**RE: Desert Ridge Pointe Subdivision
Drainage Certification
Grading Plan Stamp Date: 11/21/16
Certification Date: 9/27/17
Hydrology File: B19D028**

Based on the information provided in your submittal received on 9/27/17, the Drainage Certification cannot be accepted for Release of Financial Guarantee until the following are corrected:

TITLE: DESERT RIDGE POINTE GRADING & DRAINAGE PLAN	
DESIGN REVIEW COMMITTEE	CITY ENGINEER APPROVAL
LAST DESIGN UPDATE	MO./DAY/YR.
CITY PROJECT NO.	745982
ZONE MAP NO.	B-19-Z
SHEET	3 OF 13

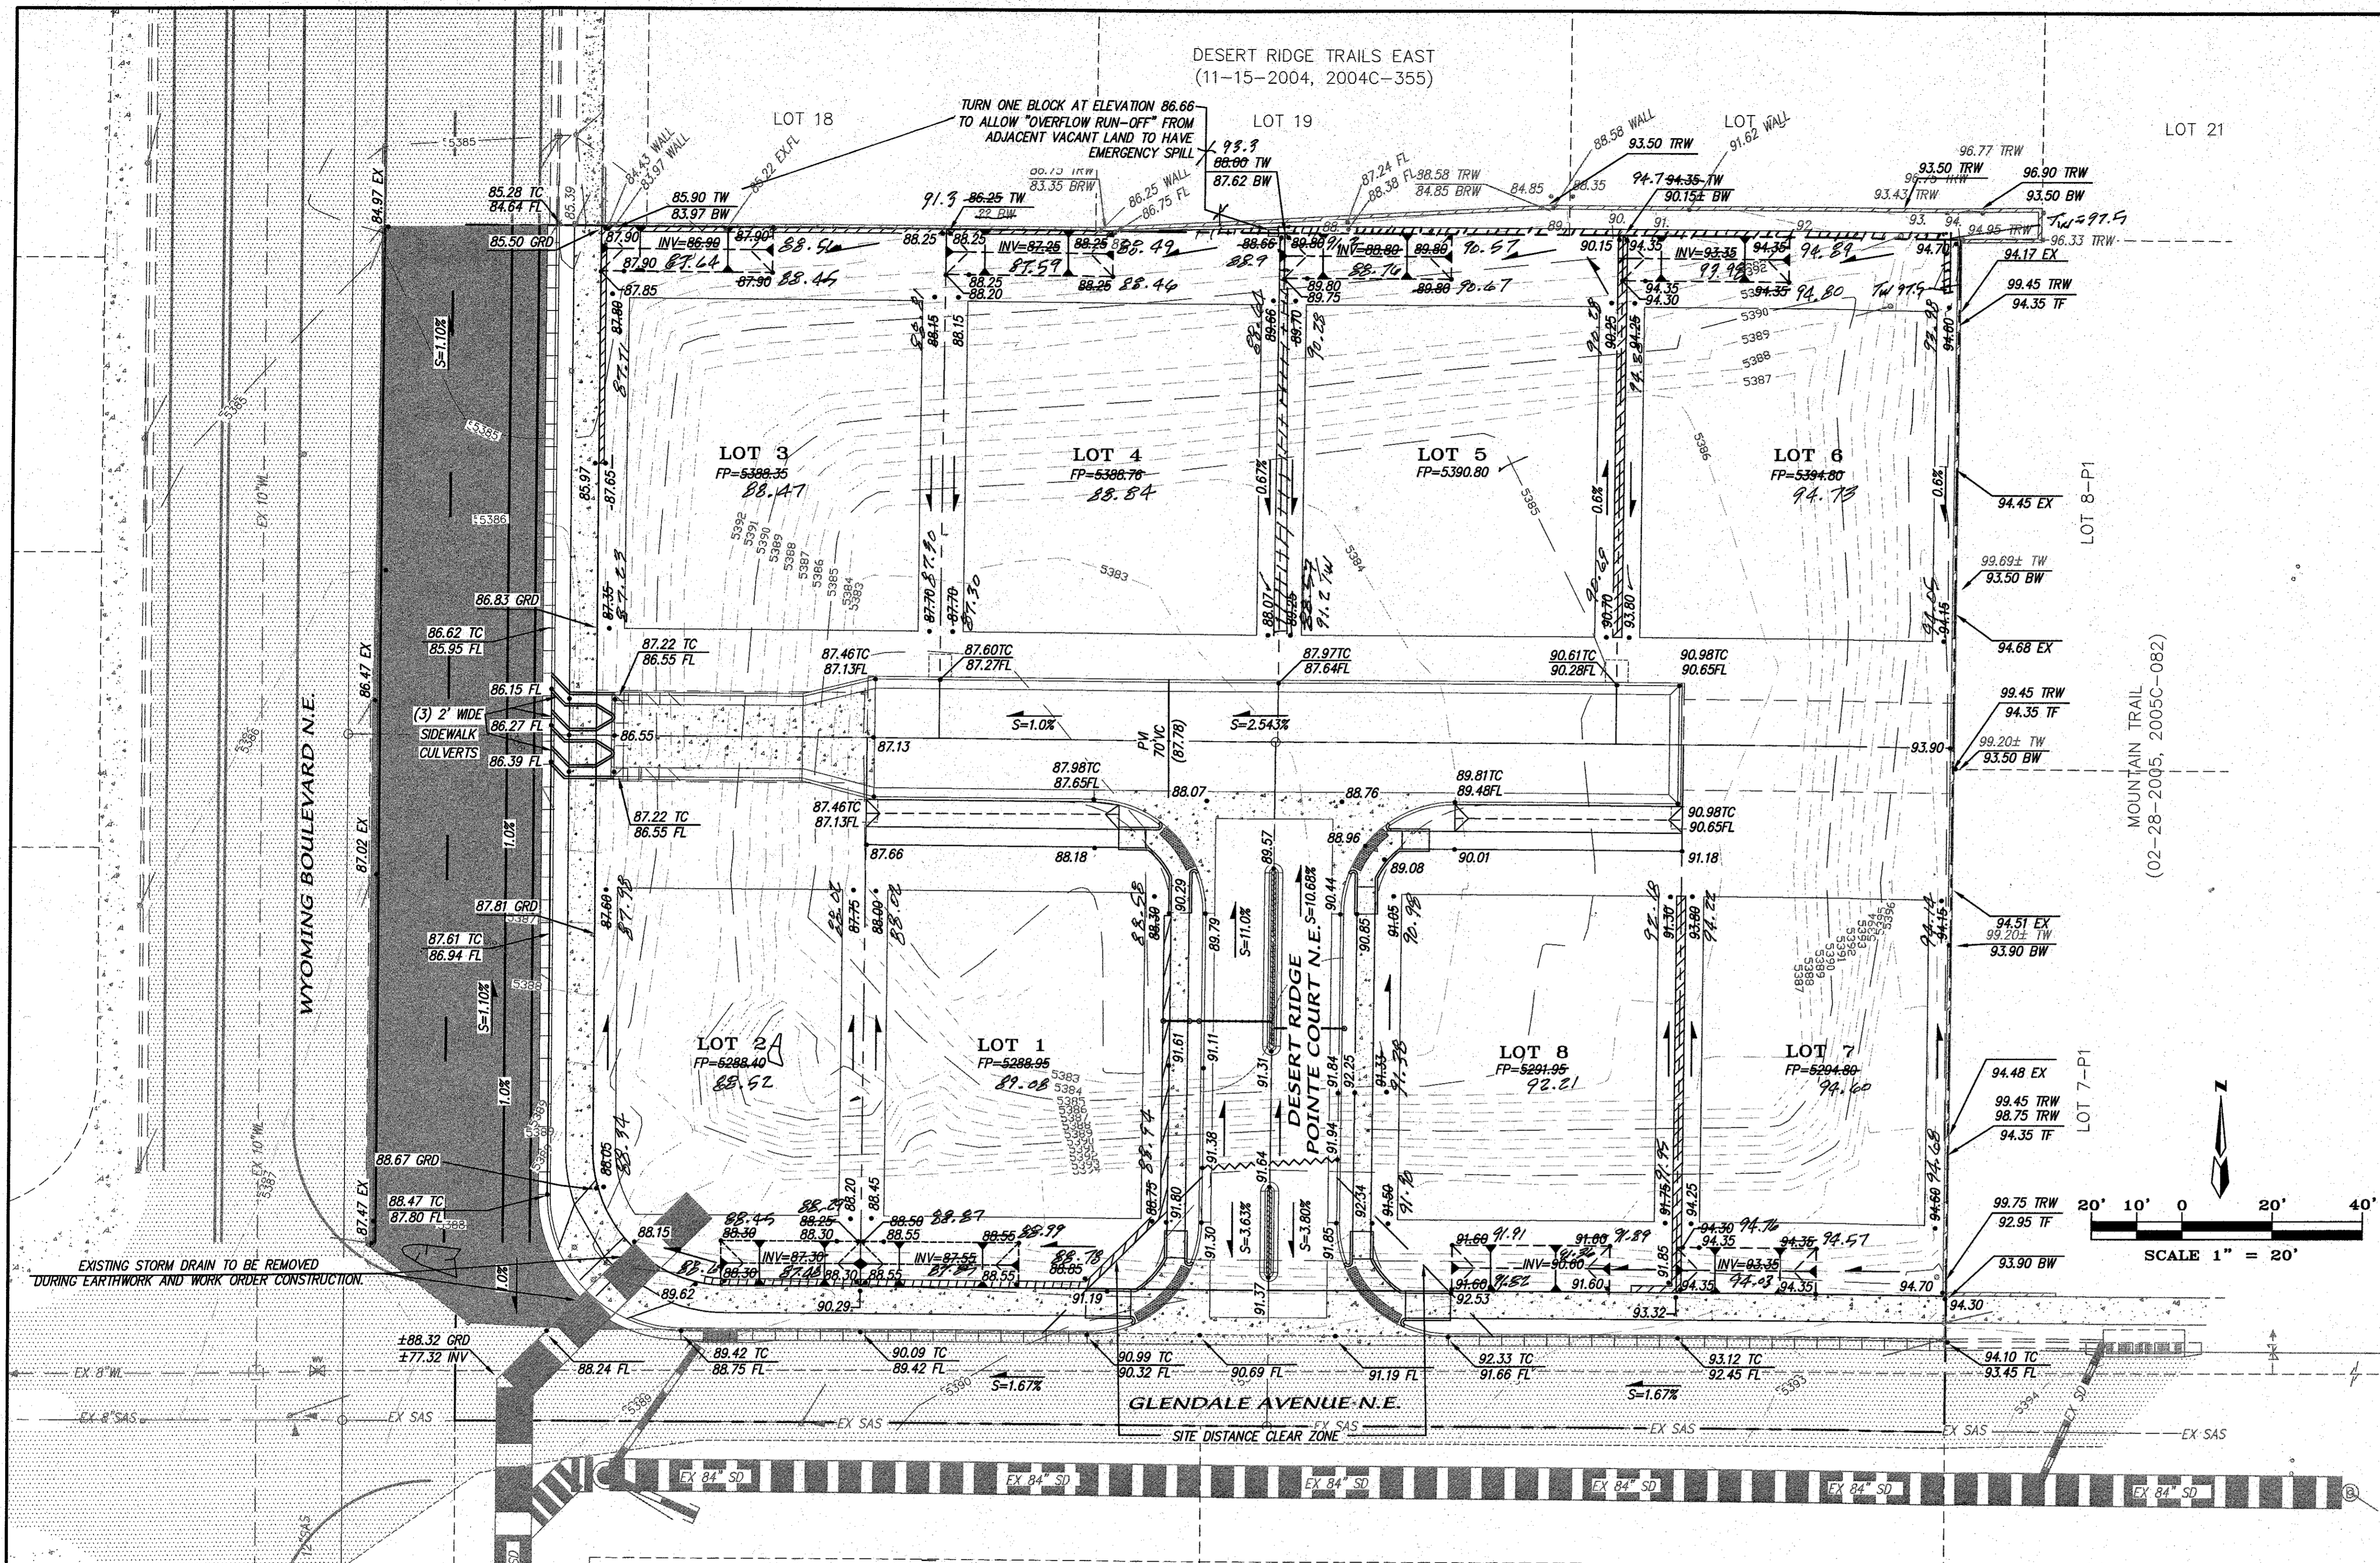
1. Correct the language in the Drainage Certification paragraph to ROFG; Certificate of Occupancy is not applicable at this time.
2. Bury and compact the bottom course of CMU (speedblock) and the exposed footer along the retaining wall on the eastern property line.
3. As-built the new retaining walls on the submittal. These were noted between lot 4 and lot 5, along the north property line of lots 4-6, and a short stub setback from the east property line of lot 6.
4. The road must be paved prior to Drainage Certification/ROFG.
